Application for Approval of Details Reserved by Condition

Discharge of details reserved by conditions 8 (substation design), 9 (roof-level photovoltaic panels), 12 (pumping station design) and 15 (water safety measures) of previous Reserved Matters approval 2025/92242 (including consideration of appearance, scale and landscaping) for erection of 80 dwellings, pursuant to Section 73 approval 2025/90105 pursuant to previous outline permission 2022/91735

Land off Hermitage Park, Lepton, Huddersfield, HD8 0JU

Application Number: 2026/90913

EDB8642, Hemmidge Park, Fenny Bridge, Huddersfield H8 8JL

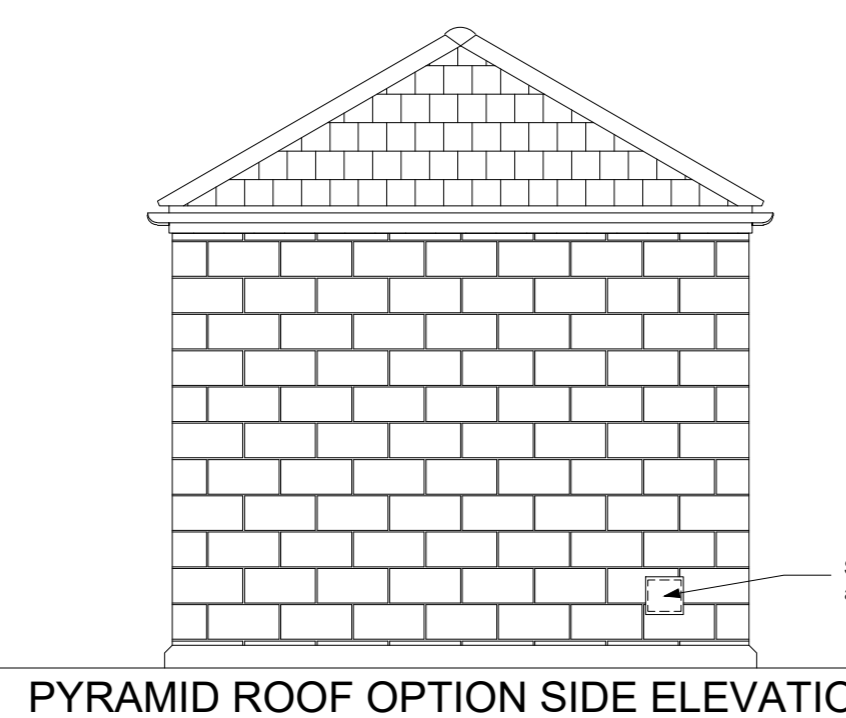
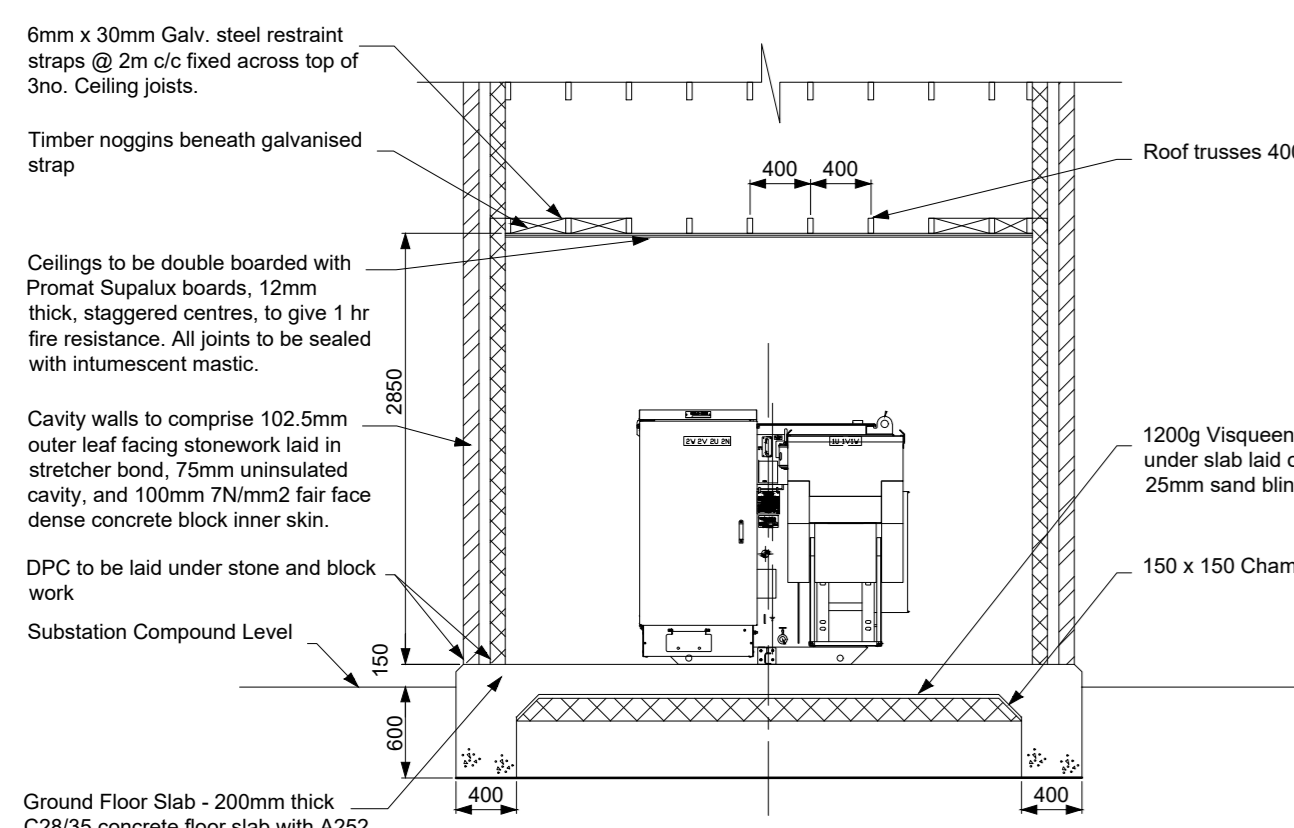
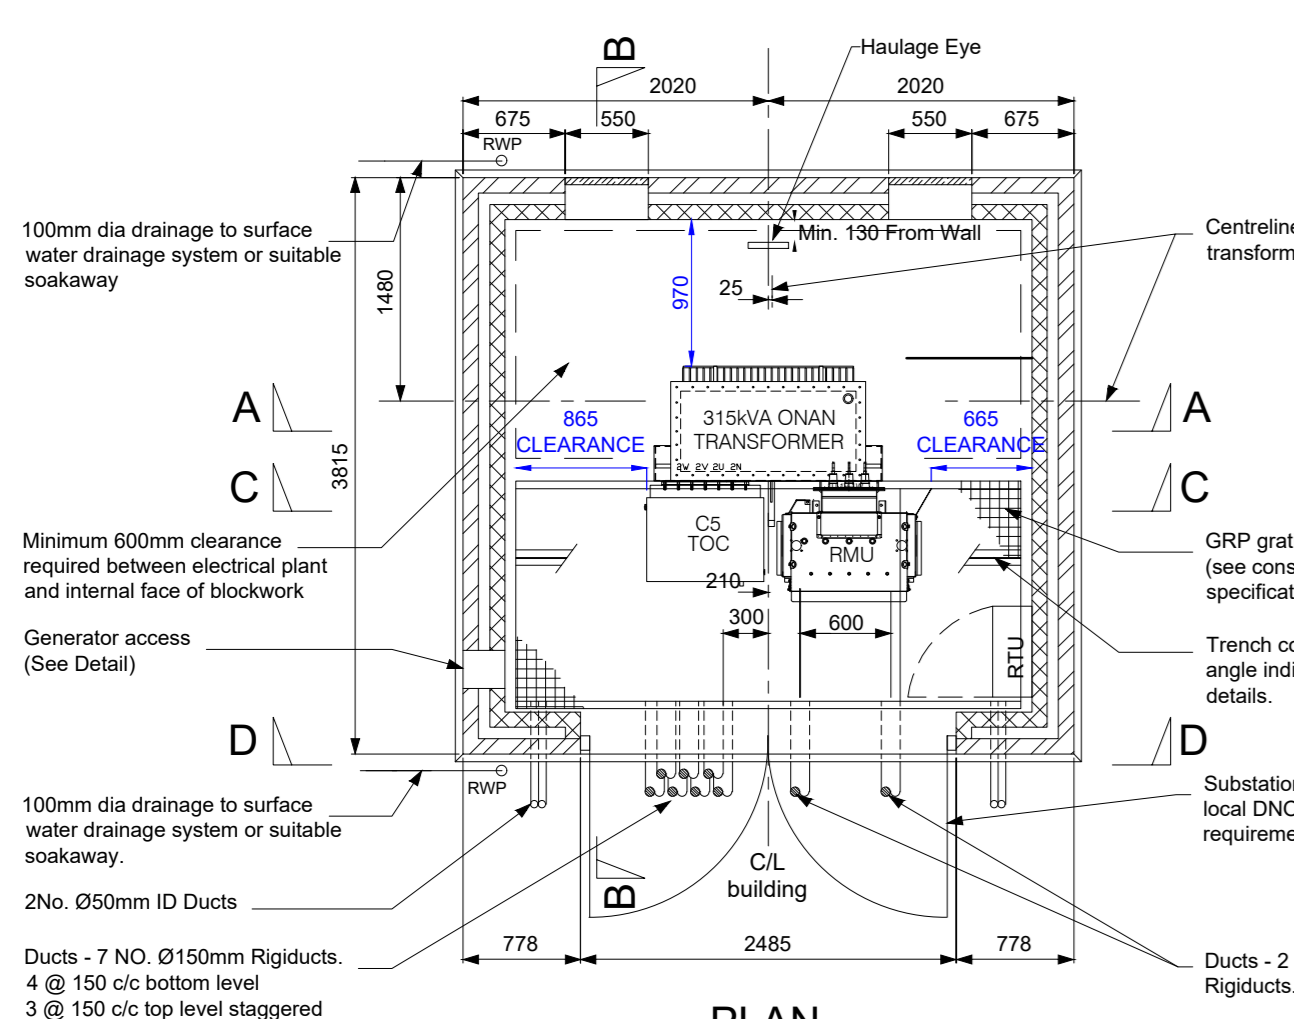
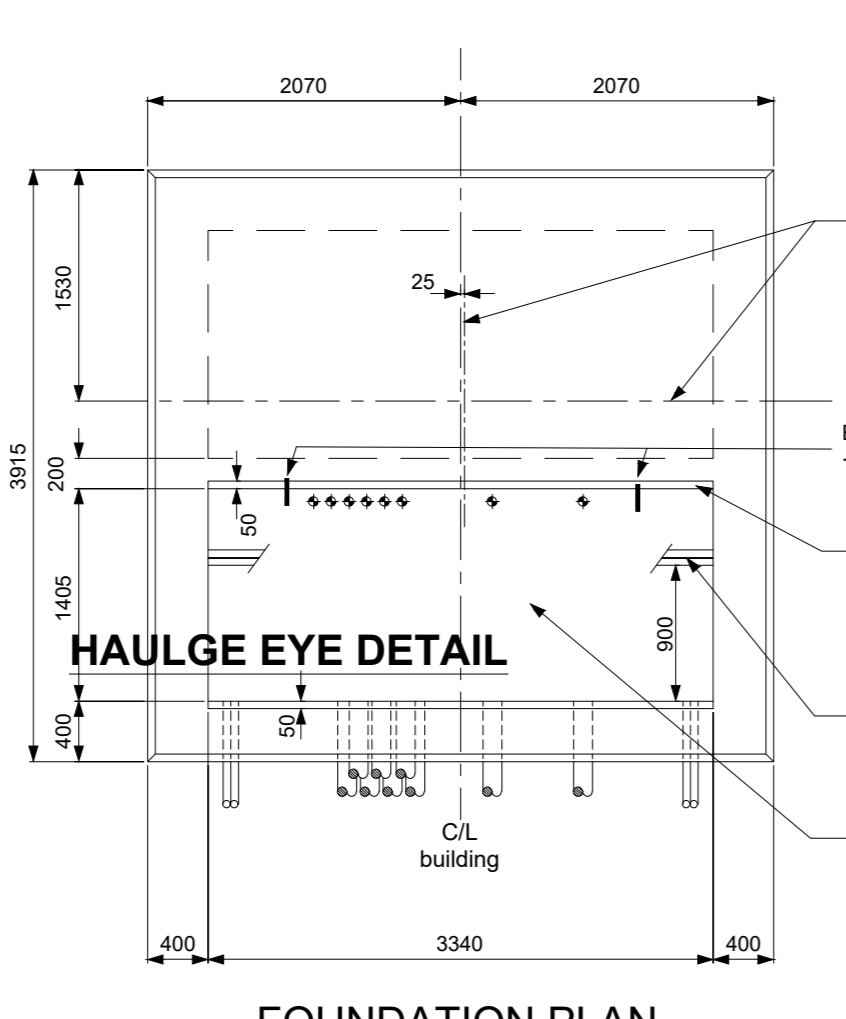
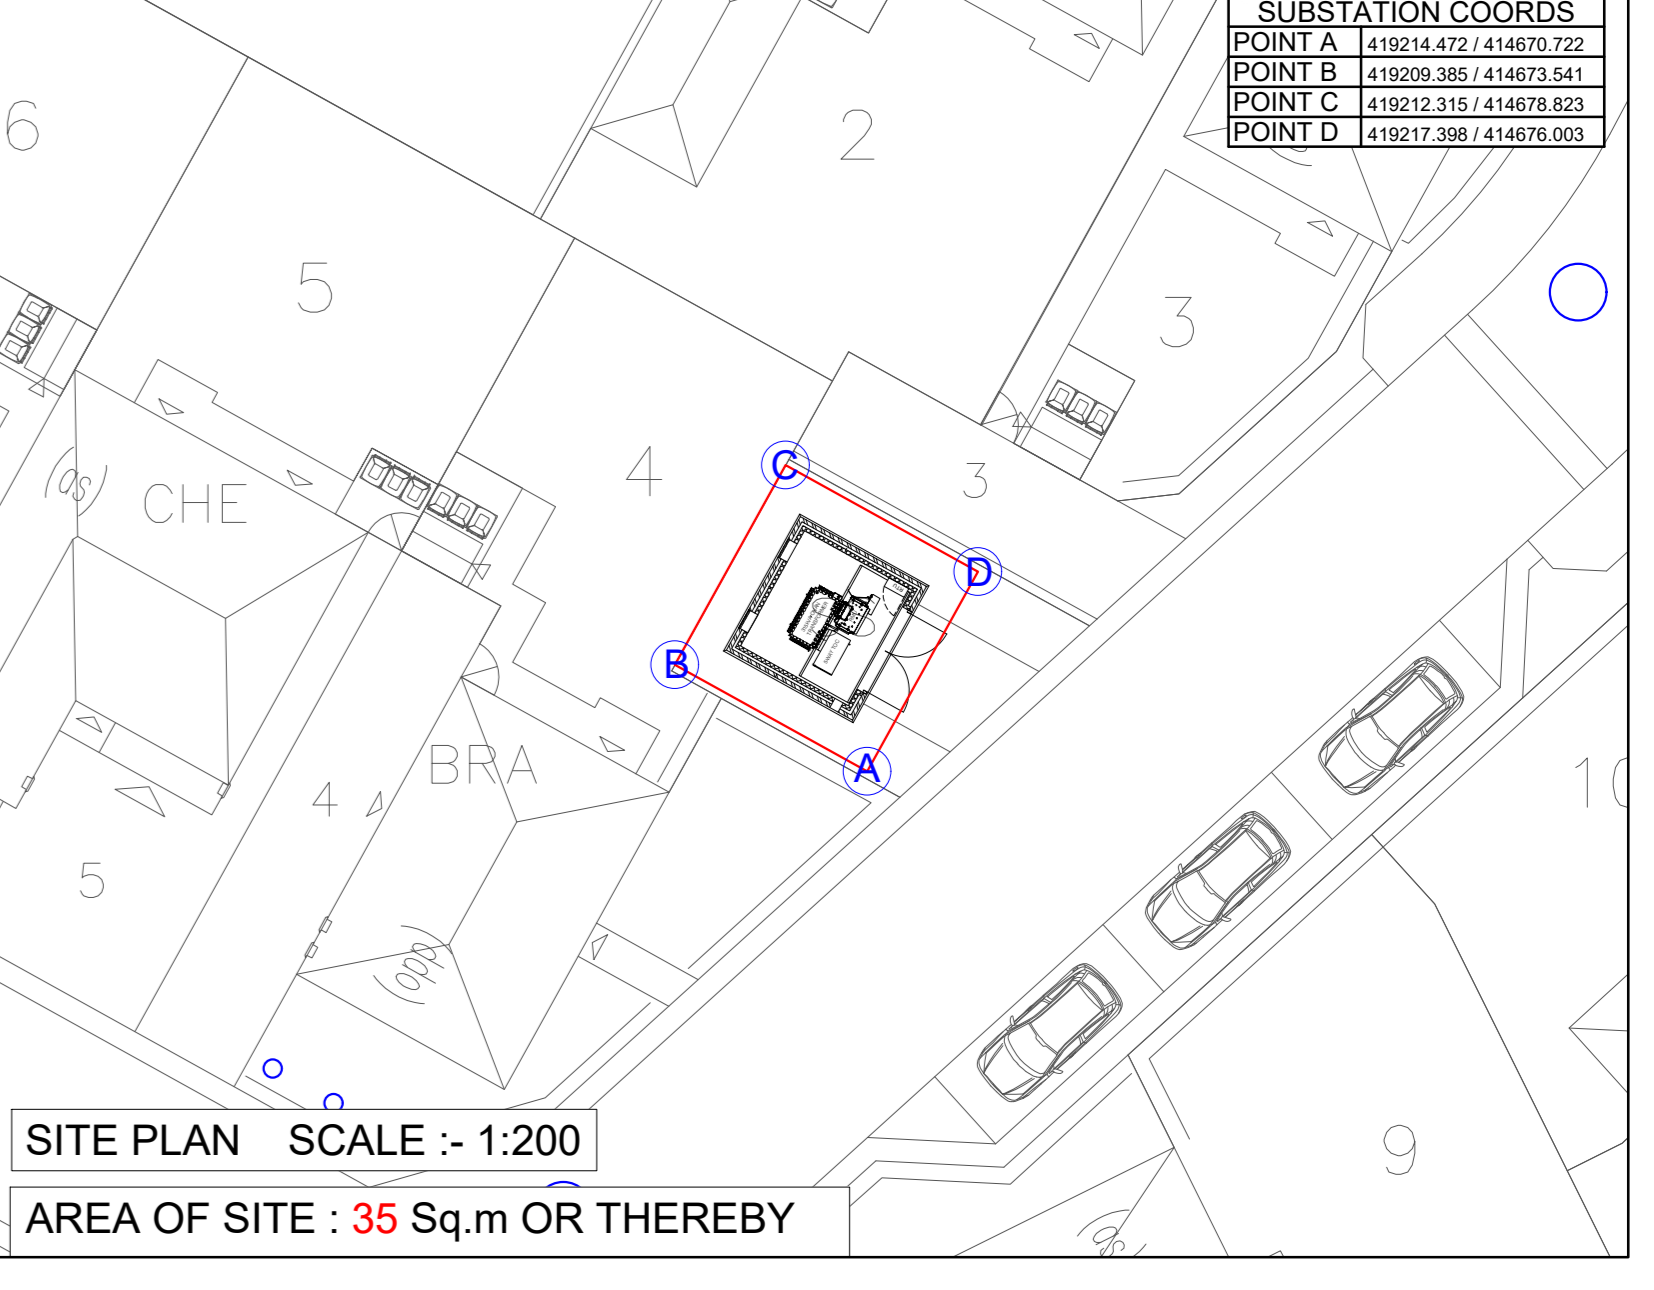
Condition 8 (substation design) – You have submitted an amended version of drawing EDB8642_NPG_EL_100_1 OF 1 rev 003 (version received 22/05/2026, omitting alternative designs of the substation) pursuant to condition 8. Under Discharge of Conditions application 2026/90503 you have confirmed that the walls of the substation would be built of Newlay Pitched Face Calder Buff artificial stone, and Russell Grampian grey concrete roof tiles would be used on its roof. You have also confirmed that the substation's doors would be polyester powder coated in Holly bush green (BS 4800 ref: 14-C-39) and that its rainwater goods would be black. These details are considered acceptable for the purpose of condition 8, and are hereby approved. Please be reminded of the further stipulation of condition 8, which states:

Drawing Title  
**Foul Pump Station Elevations  
(1.8m High Close Board Mortice  
Fencing Set in Concrete Posts with  
Concrete Gravel Board)**

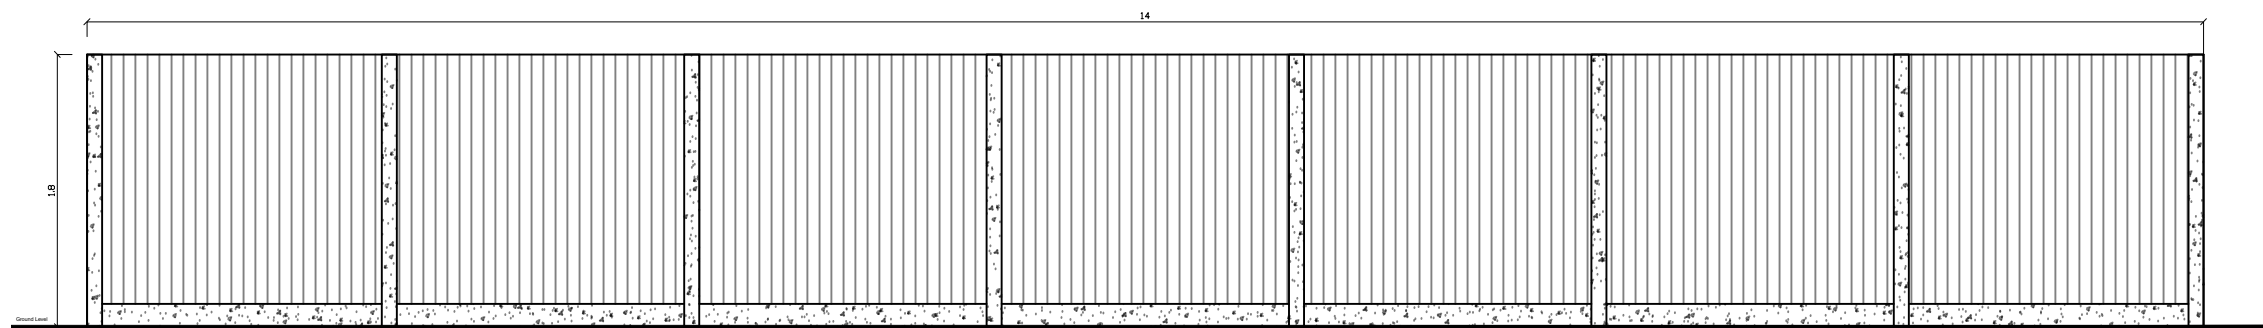
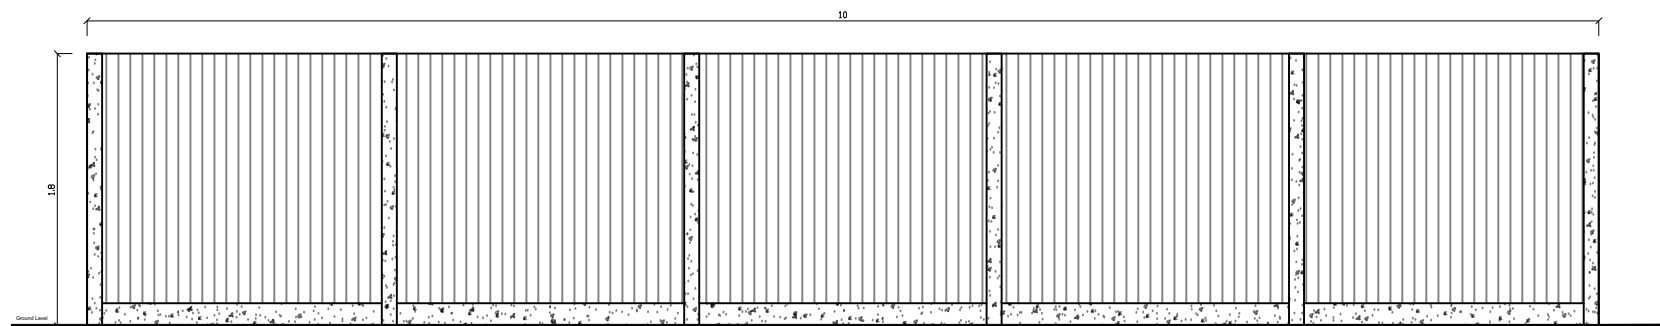
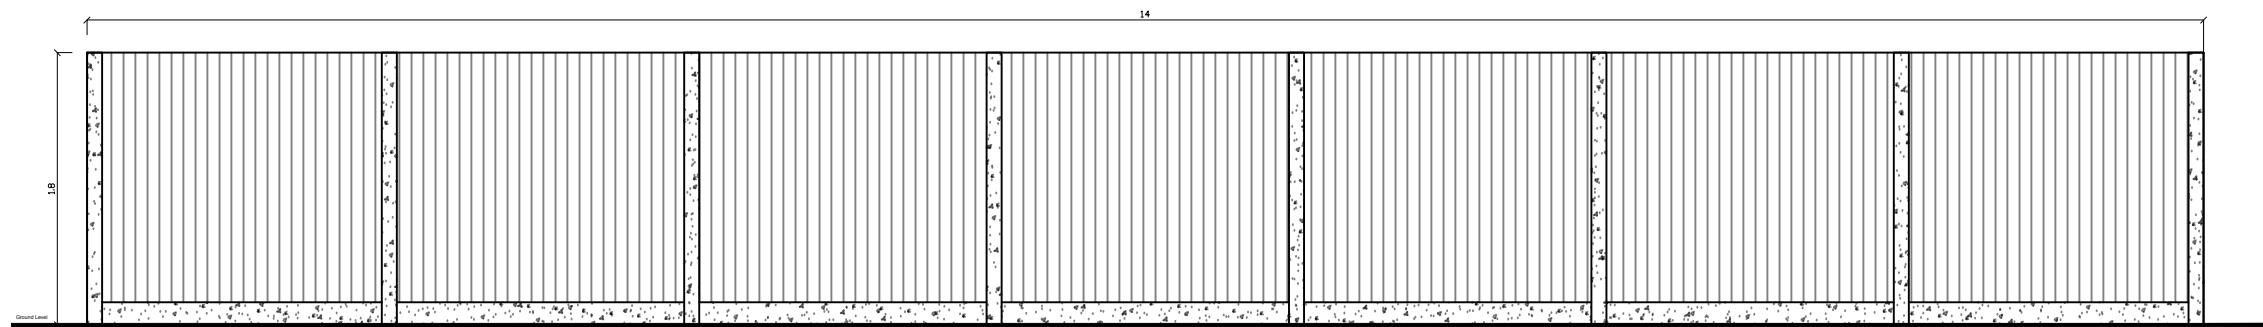
Condition 12 (pumping station design) – You initially submitted drawings PS-01 and 5728-31559-004 rev B pursuant to condition 12. These included details that were unacceptable or unclear. On 22/05/2026 you advised that a 1.2m vertical railing could be proposed around the pumping station. As advised on 09/06/2026, such a boundary treatment would be considered acceptable, however updated drawings would need to be submitted, and the other comments made on 18/05/2026 would need addressing. Condition 12 will be considered further once updated drawings have been submitted.
